**EES****Entitlement and Engineering
Solutions, Inc**

May 06, 2015

Subject: **Del Norte Dialysis Center, 5207 San Mateo Blvd. NE**
Final Drainage Submittal Response
Project: F17-D095A

**C5.0**

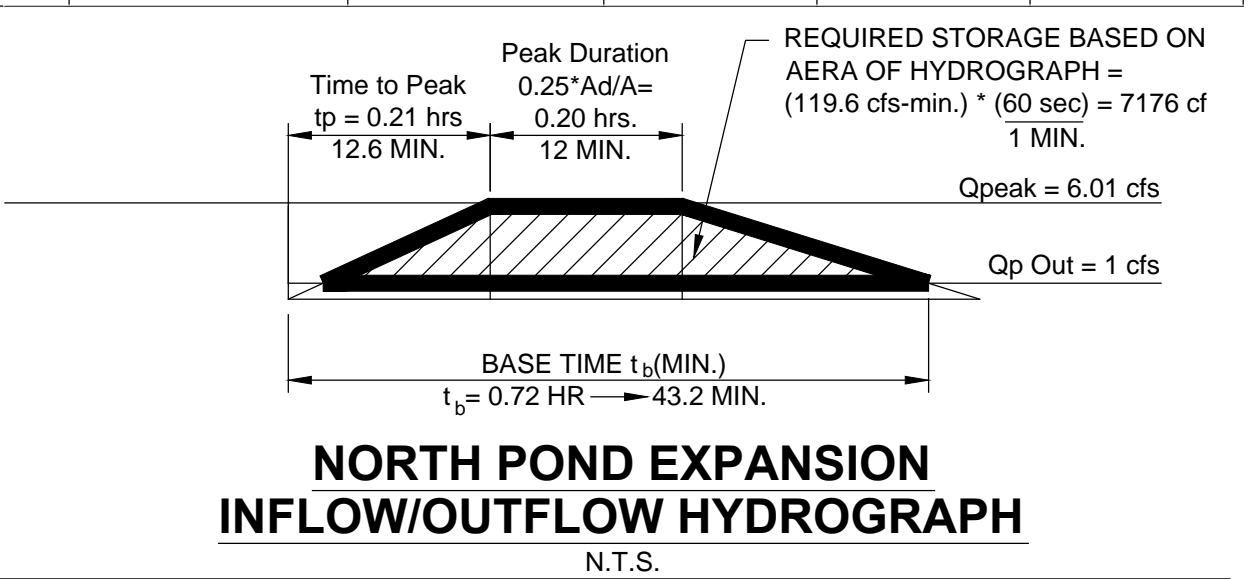
2. On the Sheet C5.0, include your computed WSEL for the 100 year storm, the total volume provided for the storage pond, and the corresponding pond volume at the WSEL.
All information as described above is now shown on Sheet C5.0 in the text box titled Overall North Pond Storage at the top of the sheet.

3. Also, on Sheet C5.0, show all basins that contribute to the north pond which shall include all off-site storm water runoff from the Golden Corral parking lot. **Done. The offsite stormwater tributary to the North Pond is shown as GC3 and this basin was recreated using the Golden Corral Drainage Plan (see report appendix for this plan). Basin GC3 incorporates Basins DA No. 12 & 13 on the Golden Corral Plan.**
